Please upload email to R/62/26/PL, planning, consultation response, ECO

From: Jonathan Best <Jonathan.Best@arun.gov.uk>
Sent: 12 May 2026 11:53
To: Planning.Responses <Planning.Responses@arun.gov.uk>
Cc: Hebe Smith <Hebe.Smith@arun.gov.uk>
Subject: R/62/26/PL

Croft Works 52 Mill Lane Rustington BN16 3JN.

I have reviewed this application with regards to ecology and Biodiversity Net Gain.

PROPOSED FRONT ELEVATION (EAST)
PLOT 1

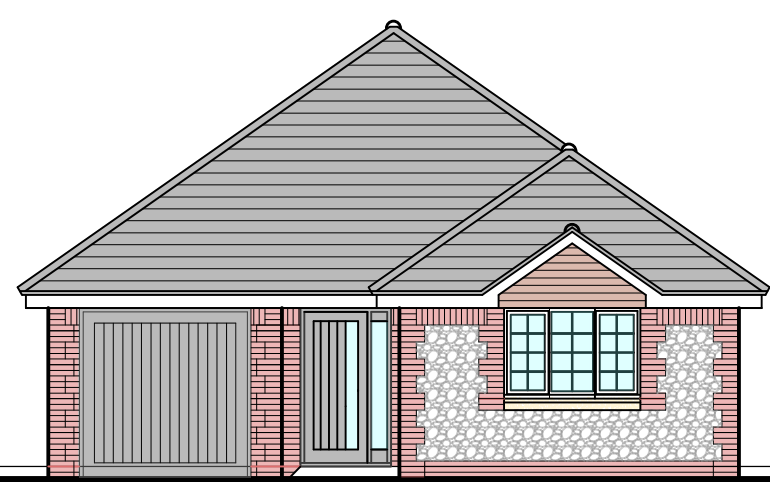
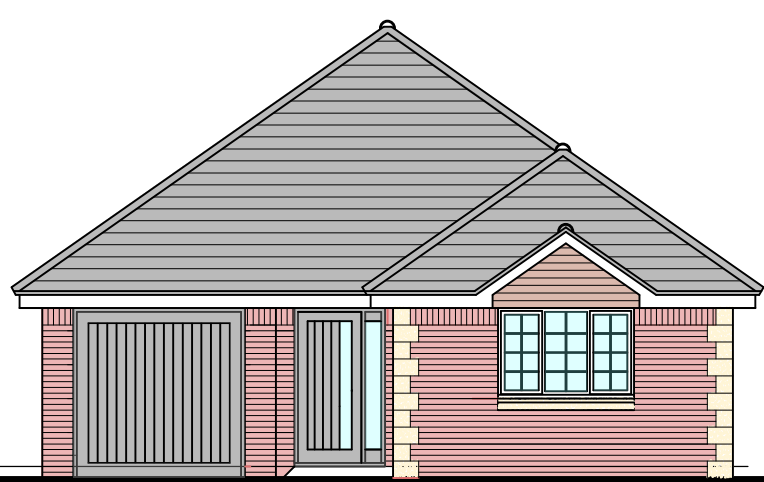
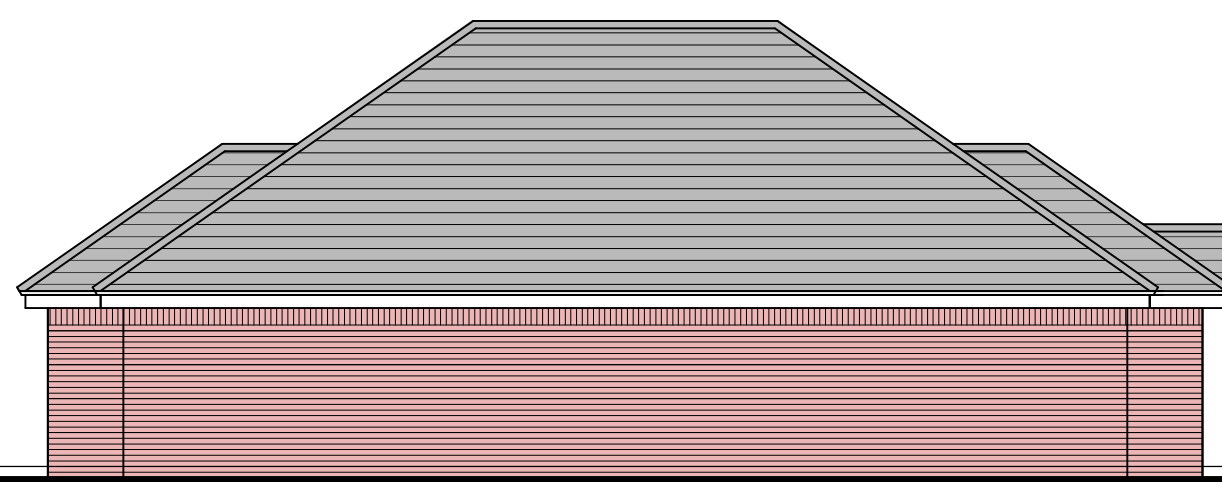
I advise that the bird boxes are integral swift bricks located facing east on the dwellings. New trees will be too small to support nest boxes.
